Airly Mine Modification to Development Consent DA 162/91

I object to the Airly Mine Modification 3.

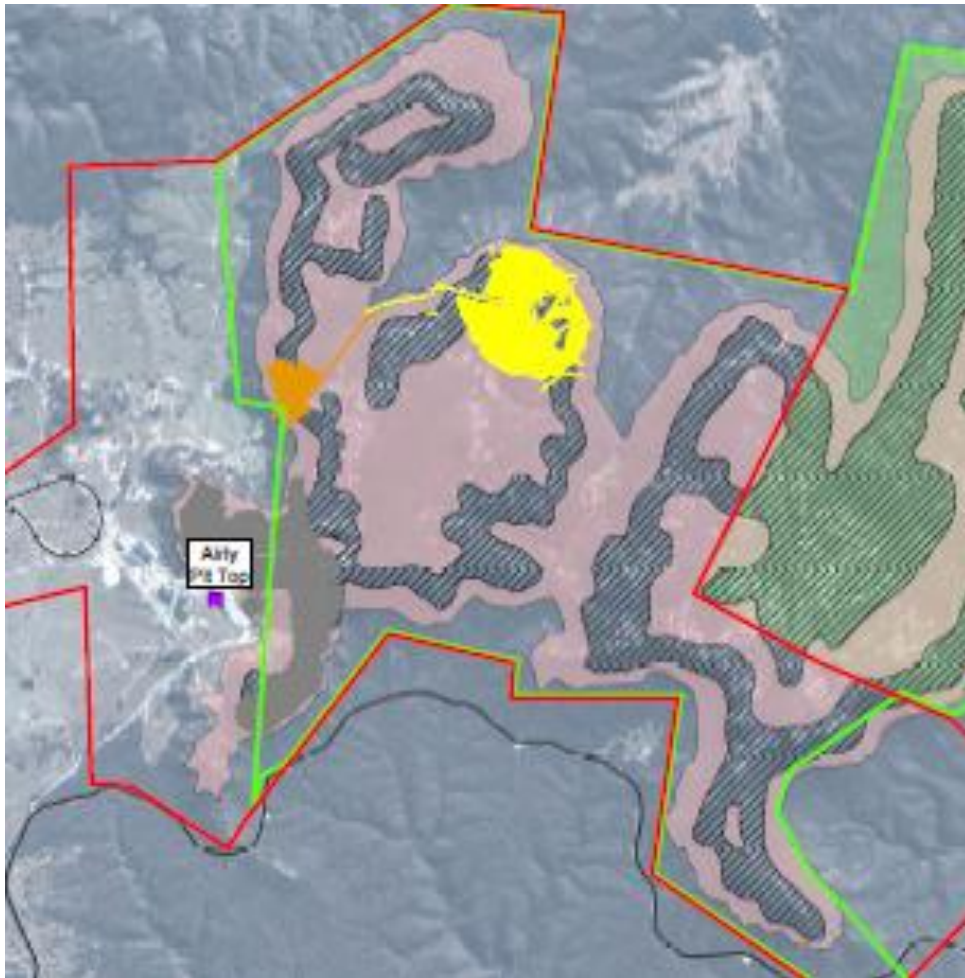
I would like this clarified. i.e. will there be widespread full extraction after the period of the Modification? (in the areas shown on Figure 5)

I do not want to see any further future mining in the Area Excluded from DA162/91 initial Consent Area as shown in Figure 5 of the Environmental Assessment. This includes the main part of Genowlan Mountain. i.e. no future mining to the east of the current Project Application Area.
